COUNTY COUNCIL'S RESPONSE TO CONSULTATION ON THE FOLLOWING DEVELOPMENT PROPOSAL

Application No: 18/00193/REM

Proposal: Reserved matters application to 14/02156/OUT - for appearance, landscaping and layout (including the layout of the internal access roads, footpaths and cycleways) for 44 dwellings

Location: Land South Of Cotefield Business Park Oxford Road Bodicote

Road 1  
Horiz. 1:500 Vert. 1:50

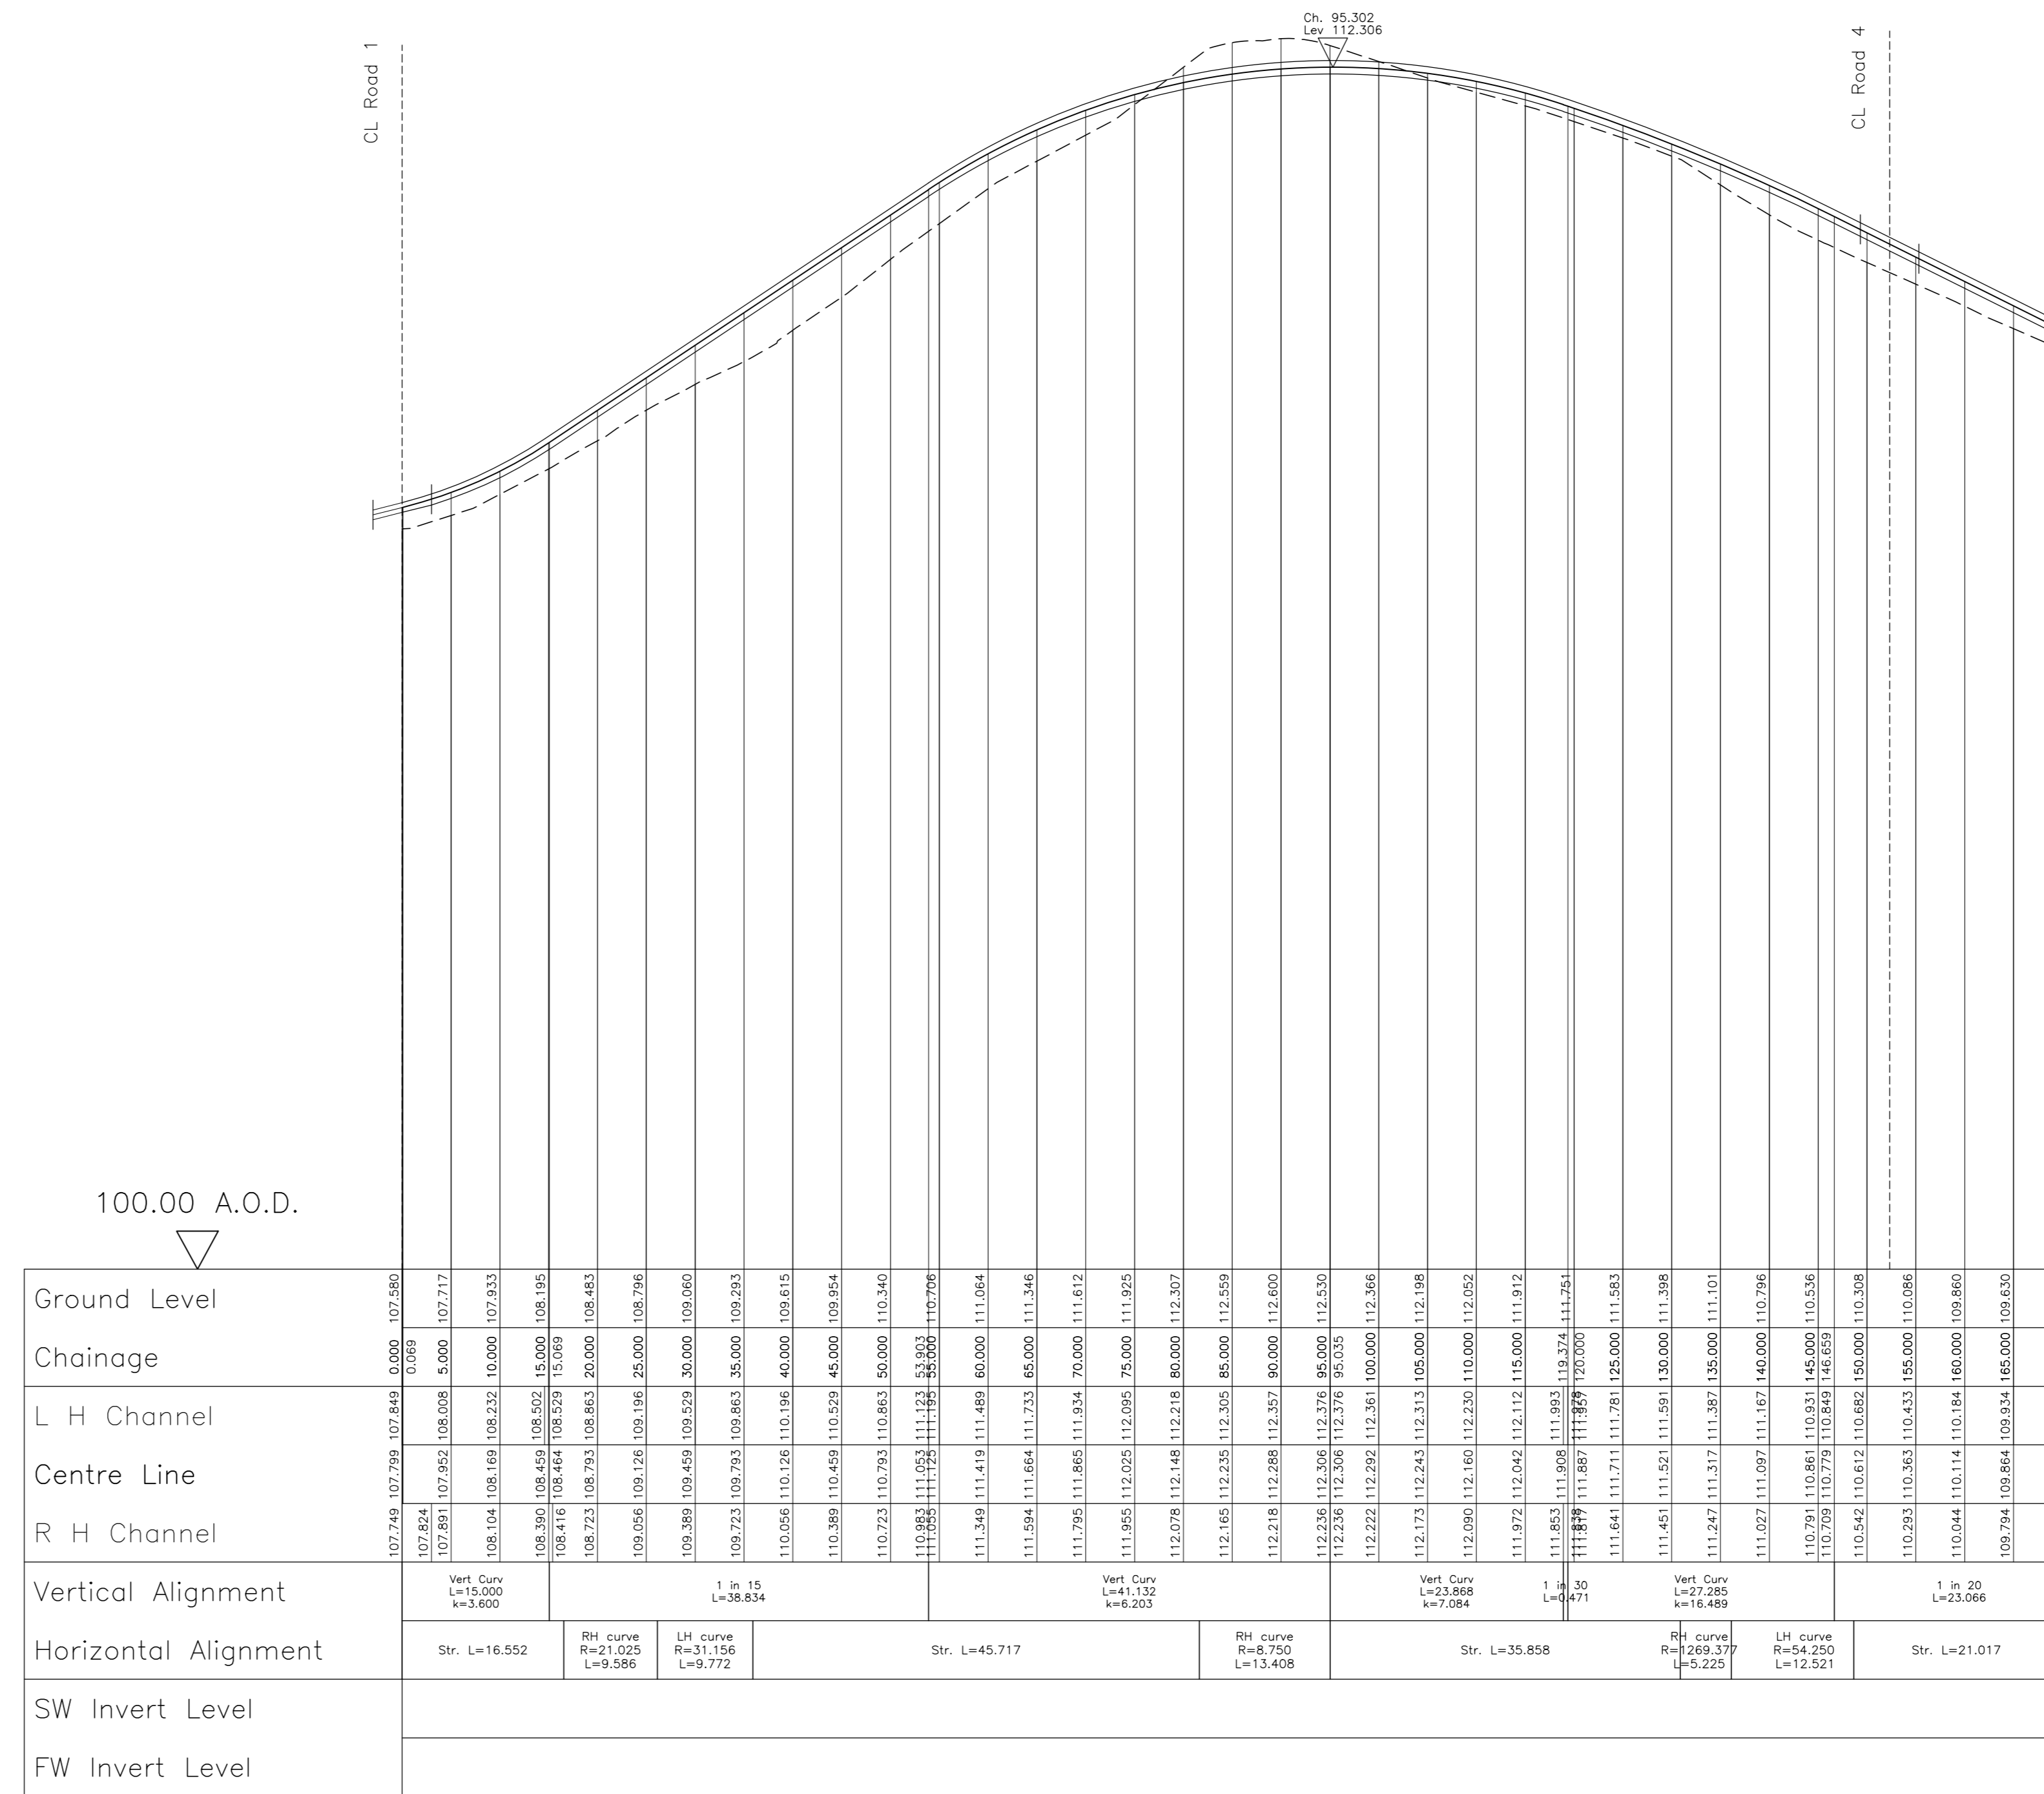
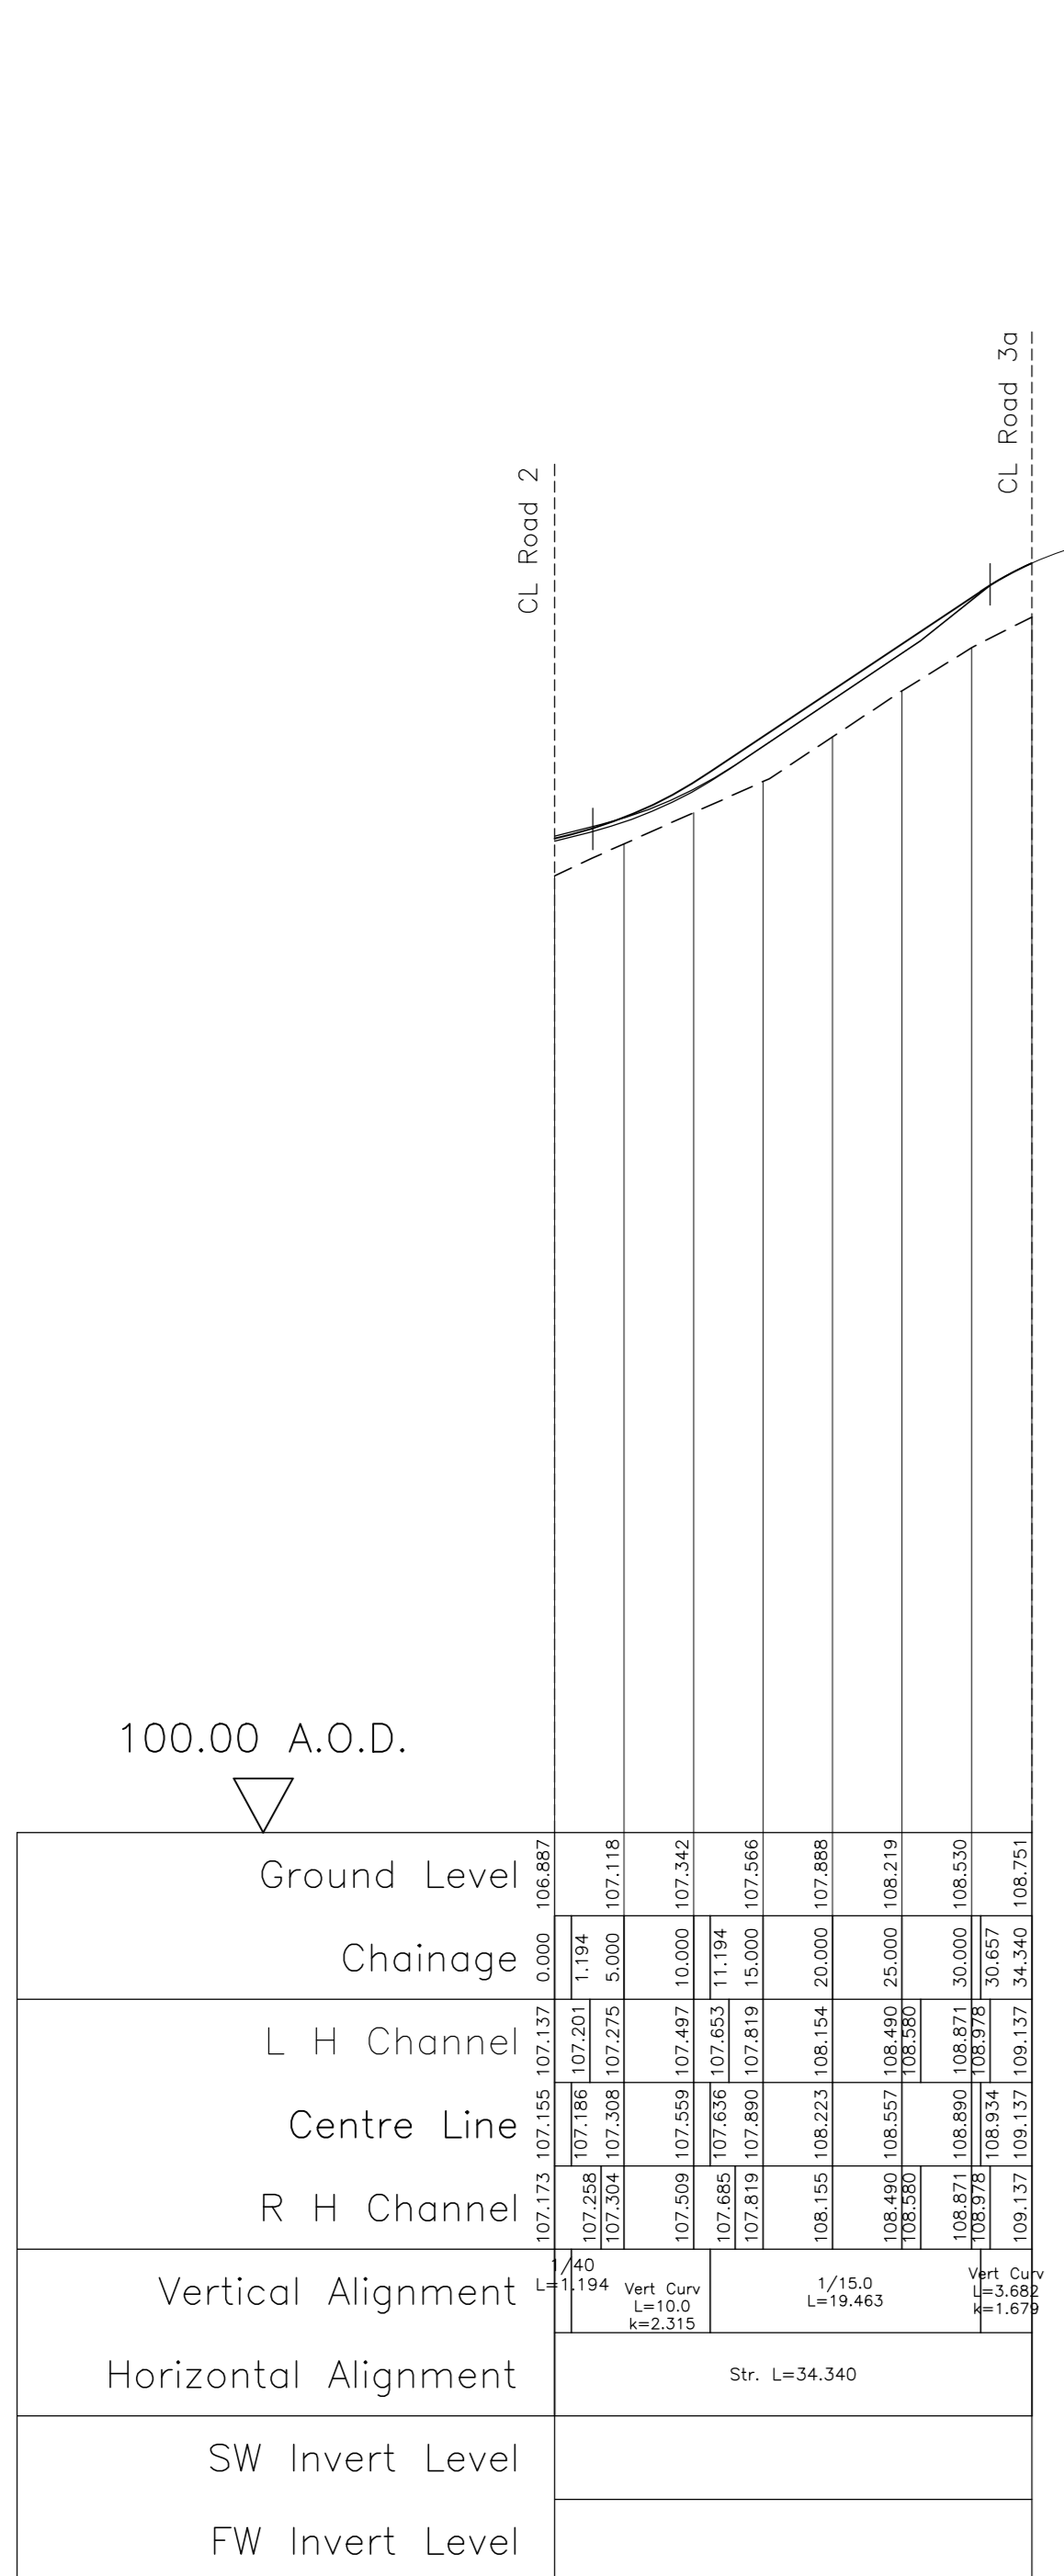
- This reserved matters application applies only to the layout of part of the site covered by the outline permission. It is difficult to assess pedestrian permeability without considering the layout of the whole site.
- Parking levels are very tight and rely on garages being counted as parking spaces.
- There is therefore a risk of on-street parking which could obstruct vehicular access and/or footways
- Refuse vehicle tracking at junction of Road 1 and Road 4 – vehicle uses whole of opposing carriageway when making the turn from Road 1 into Road 4, which may require vehicles waiting to exit Road 4 having to reverse, causing a safety risk.

The vehicle tracking has been carried out using a large refuse vehicle. There is an issue with the turn from Road 1 into Road 4 as described above. Additional visibility should be provided across plot 44 to reduce the risk.
